RESPONSE TO SUBMISSIONS – SSD-80814238

ROAD 1 DATA CENTRE, 1-5 KHARTOUM ROAD, MACQUARIE PARK

**B99 VEHICLE SWEEP PATHS**

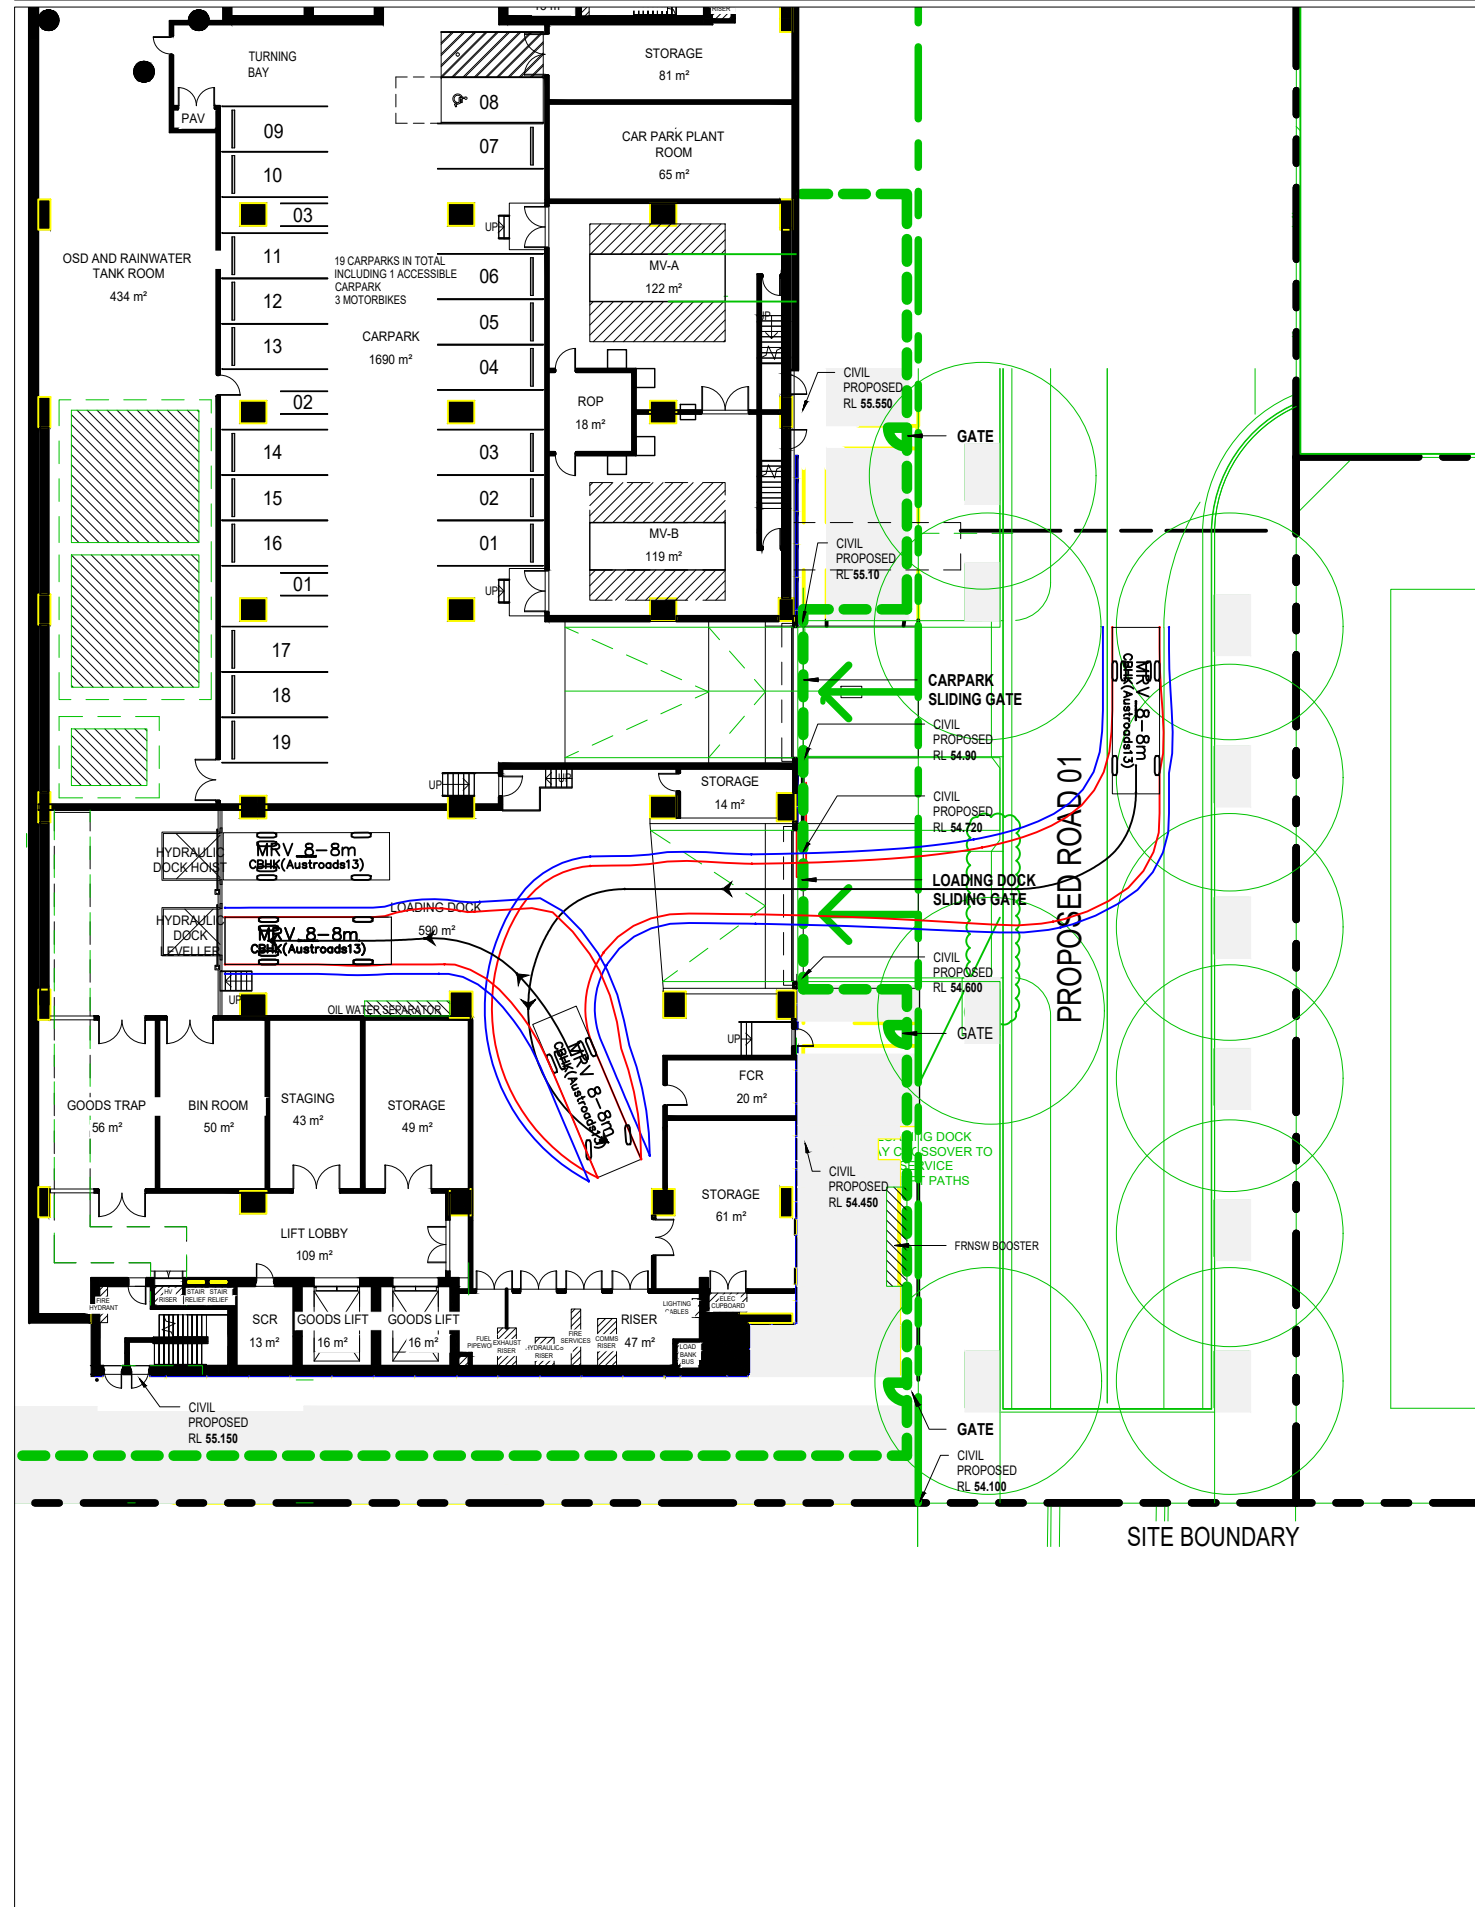
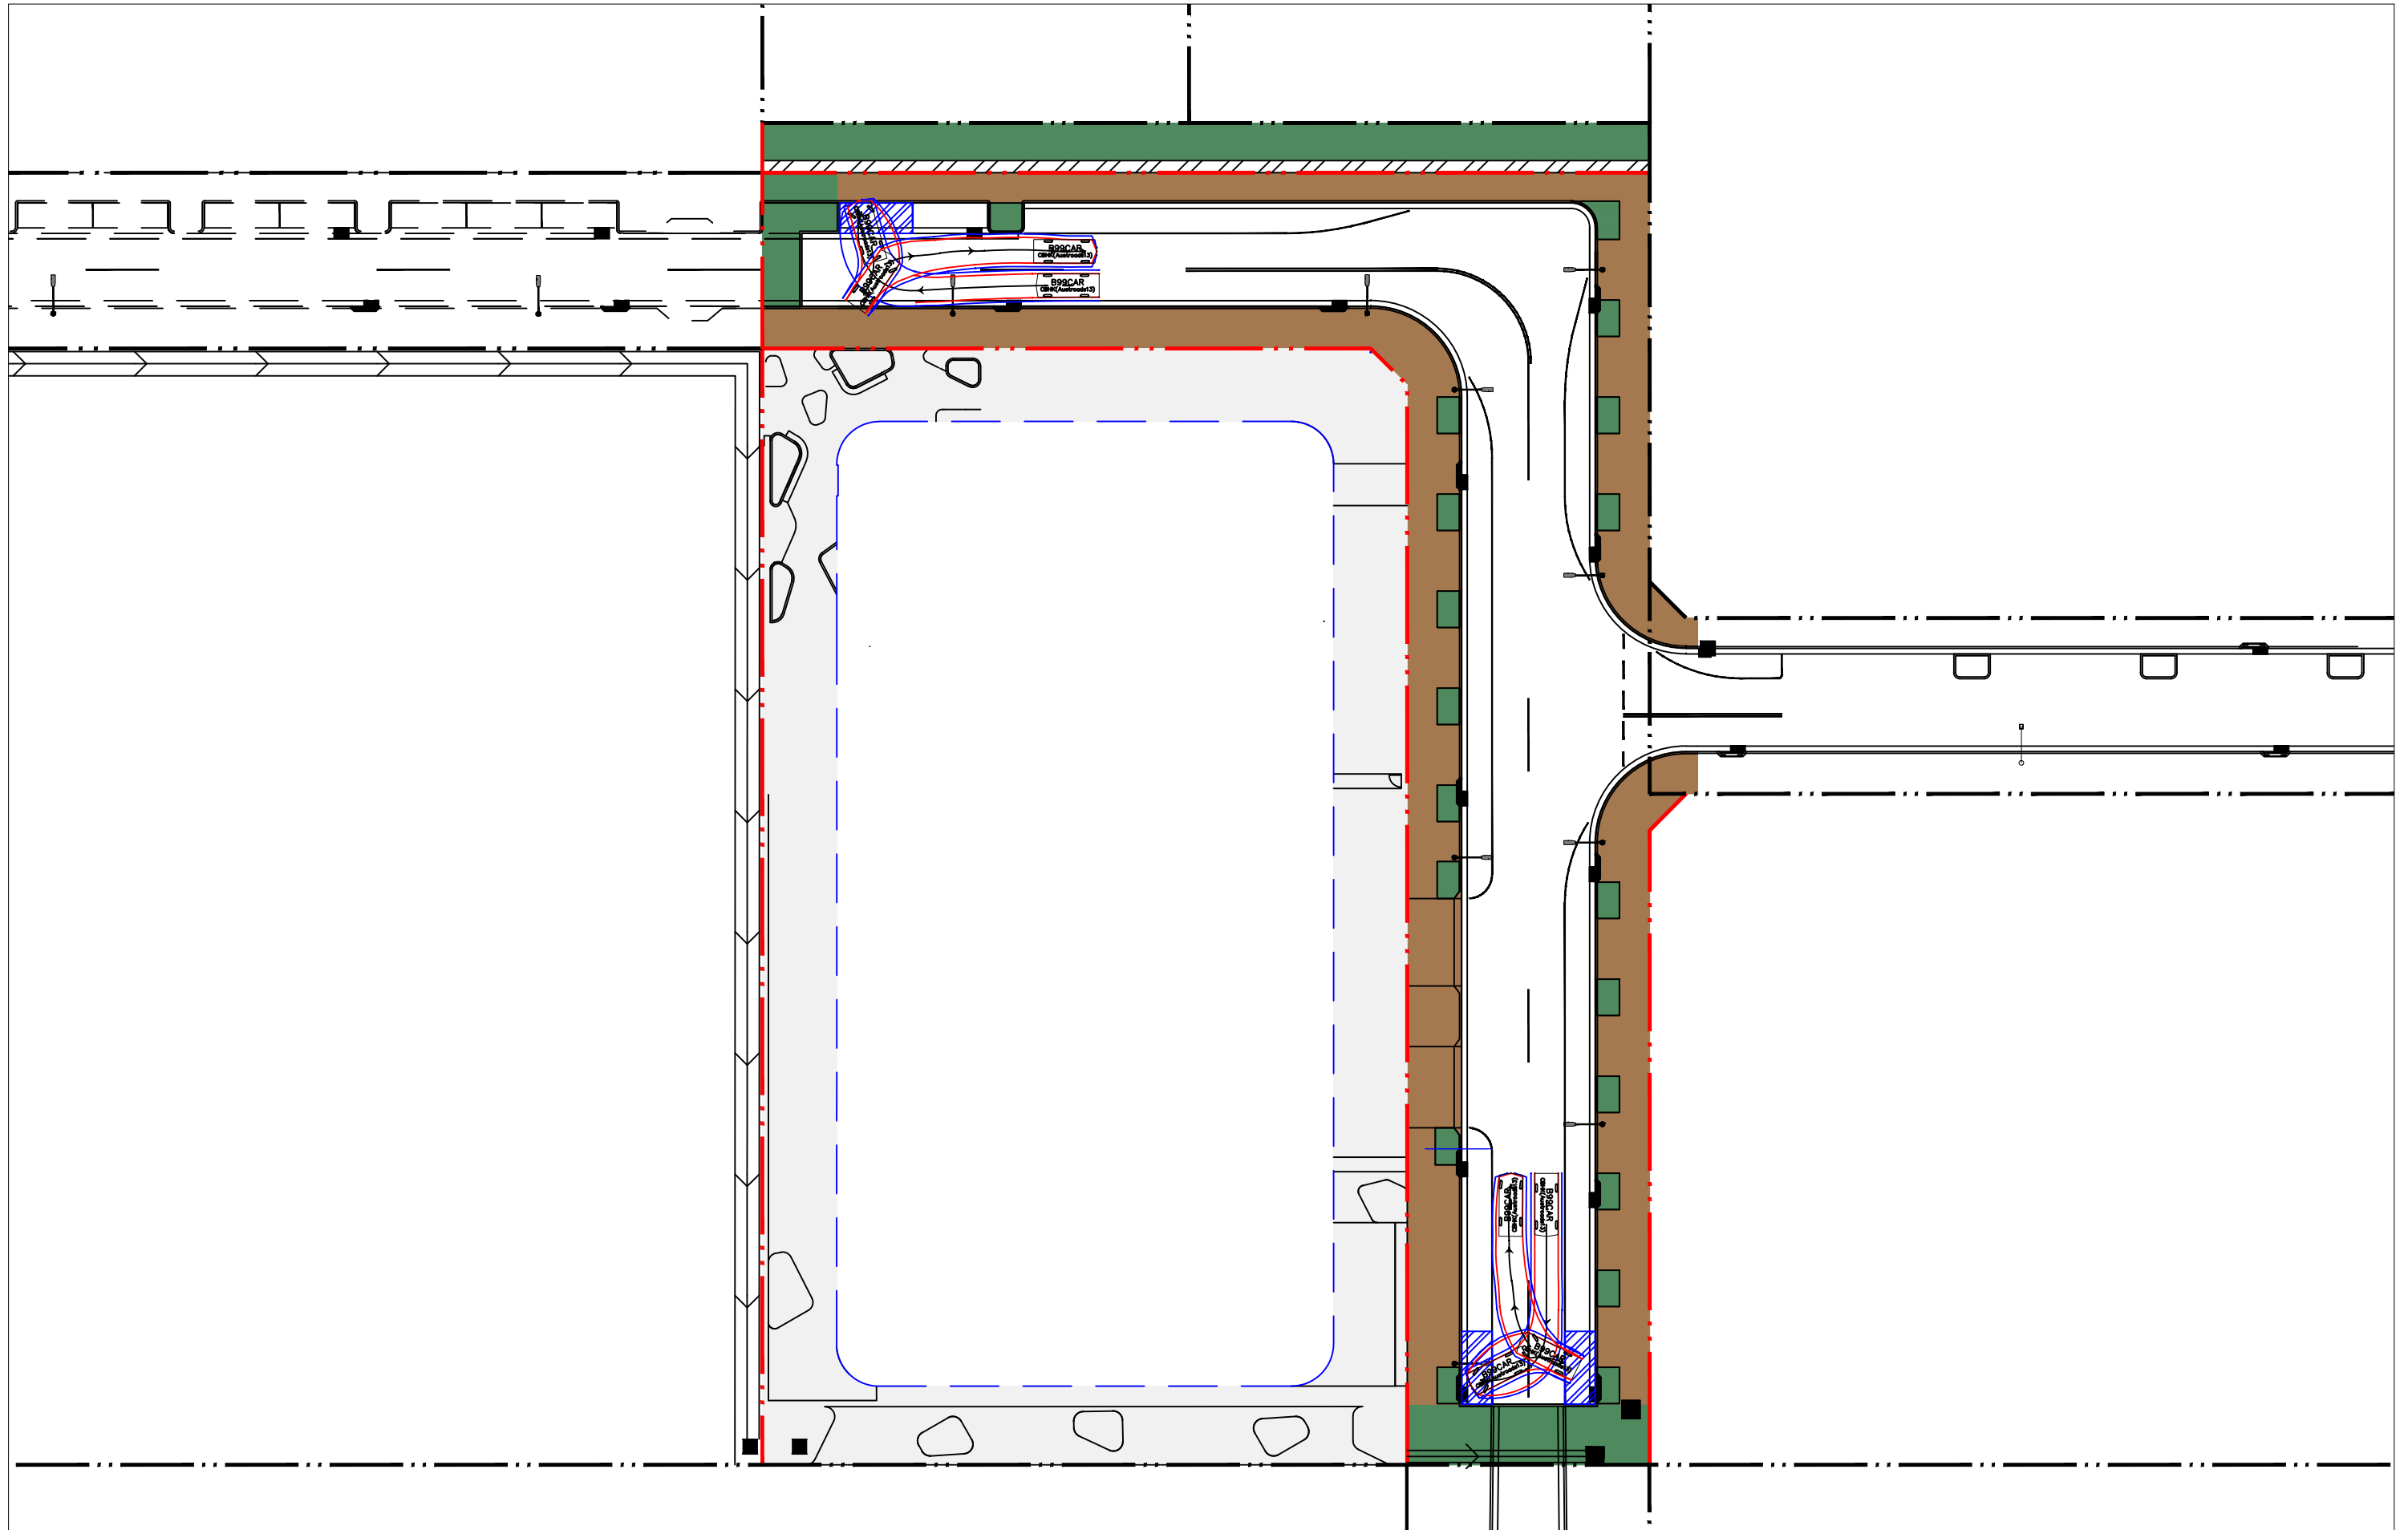
<p><u>Traffic and Parking</u></p> <p>Clarification is required as to why this proposed data centre does not require 19m/20m long trucks, which are typically proposed for each of other data centres in Macquarie Park. This clarification is requested to address potential future challenges related to operating 19m/20m long trucks at the site.</p> <p>It is requested that an estimate of truck trips be provided based on the site's operational and maintenance requirements and assess their impact on the local road network. Specify the largest truck size and include swept path analyses for inbound and outbound movements at the intersections of Talavera Rd/Road 22, Road 22/Road 1, ensuring a MRV can safely pass a B99 car, and at the site access driveway.</p>	<p>The proposed development comprises a data centre with four floors of technical data floor space (accommodating eight data houses) with a data hall GFA of approximately 6,572sqm. It is substantially smaller in scale compared to other neighbouring data centres in Macquarie Park. For this reason, the operational servicing requirements differ, and the data centre use does not necessitate regular 19m/20m truck movements.</p> <p>Day-to-day servicing will be undertaken by small to medium rigid vehicles up to 8.8m in length. The loading dock access driveway and on-site manoeuvring areas have been designed to ensure these service vehicles can enter and exit the site in a forward direction and without the need to queue or dwell on the adjacent road network. Based on the nature of the use, the proposed data centre is expected to generate low service vehicle volumes, typically two to three vehicle trips per day.</p>	Attachment C

Summary of Issue Raised	Response	Supporting Document
	<p>General maintenance activities, including delivery or replacement of diesel generators, will be very rare and infrequent. These activities may require large rigid trucks or 19m articulated vehicles. When such works are required, deliveries will occur under traffic management control, with a mobile crane positioned within the kerbside and northbound traffic lanes of Road 1 across the loading dock and car park access driveways. The crane will lift generators directly into the generator racking area within the building. These works will be subject to a standard application to City of Ryde and supported by a detailed traffic management plan.</p> <p>Regarding intersection performance, the Talavera Road and Road 22 intersection was designed and constructed as part of the completed data centre at 8 Murrell Street, Macquarie Park. Council approved this intersection on 16 May 2022 in conjunction with the endorsed design for Road 22. Swept path analyses for an MRV, B99 car, and relevant design vehicles at Talavera Road/Road 22, Road 22/Road 1, and the site driveway have been prepared and are included in Attachment C.</p>
